Our Ref: TRW: L.B20133.012.WestCulburraVegUptake.docx

19 August 2015

RE: WEST CULBURRA – FURTHER REVIEW

Figure 17: Proposed Stormwater Treatment System

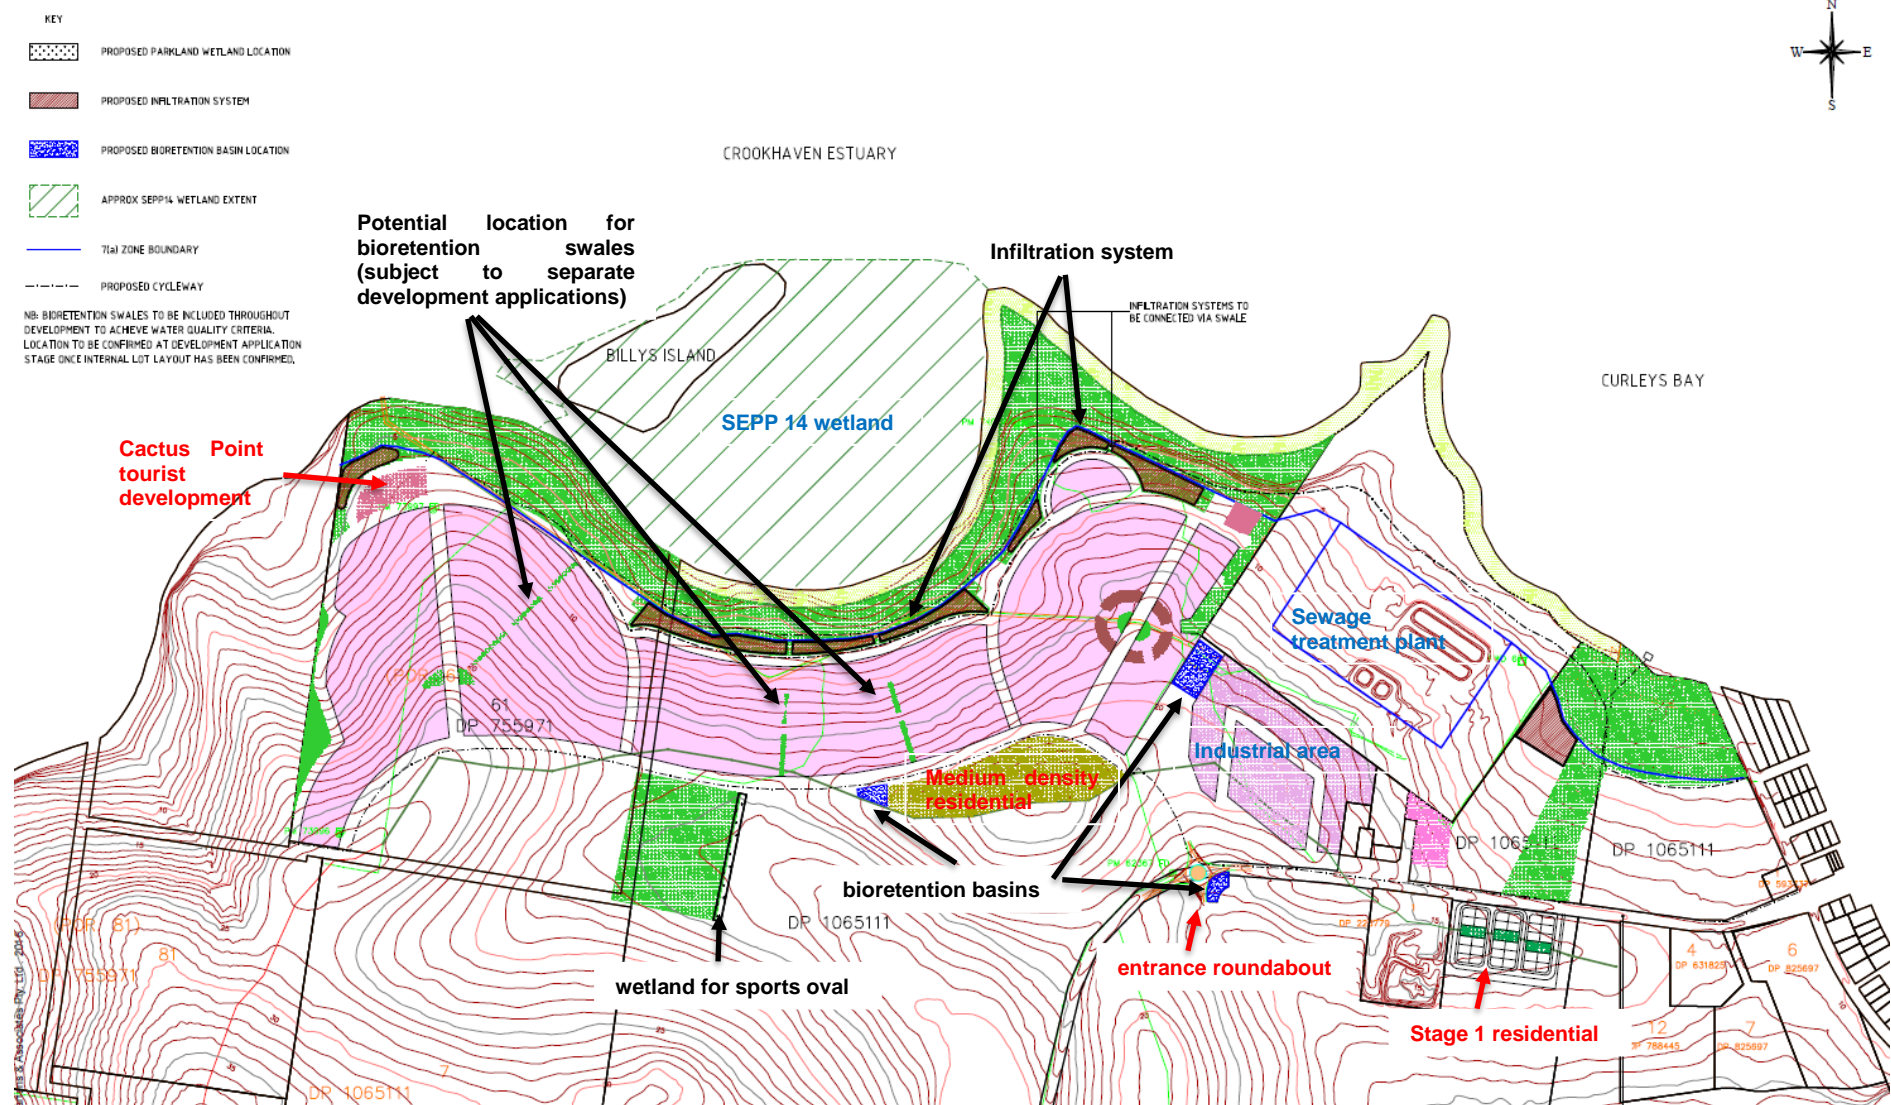
1. In terms of vegetation uptake rates, I still do not support the assumption that such uptake rates will be present on the site. While the US literature may quote some values, these would be highly site specific, dependent upon the underlying soil types (and their hydraulic conductivity) and on the background concentrations of the underlying groundwater. If anything, the increased hydraulic head on the groundwater at the West Culburra may lead to an increased flow of groundwater offsite, which in itself may also contribute to receiving environment nutrient loads. MUSIC modelling is by necessity a simplified representation of a site. As such, the inclusion of nutrient assimilation in a simplistic manner within your model really ignores the surface water/groundwater interactions which may lead to inadvertent effects that may not be beneficial to the receiving environment.

2. To have any degree of confidence that there would be any uptake, the relationship of groundwater nutrient concentrations to the likely concentrations coming out of the base of the biofilters would need to be established, and the infiltration rates assumed and therefore the residence time of infiltrated water in the uptake zone would also need to be confirmed. This would be best simulated by a proper groundwater model that could represent the groundwater/surface water interactions. I would still be concerned about the actual uptake rates present or able to be effected on-site. As far as I know, there is little data to look at low concentration uptake rates, most of the data collected on riparian zone interactions are for agricultural catchments with higher nutrient loads as per your literature review and as we know for vegetative treatments, the background concentration is the limiting factor in their efficacy. Until you could demonstrate that this has been properly accounted for, I do not support the use of vegetative uptake rates within the MUSIC model.
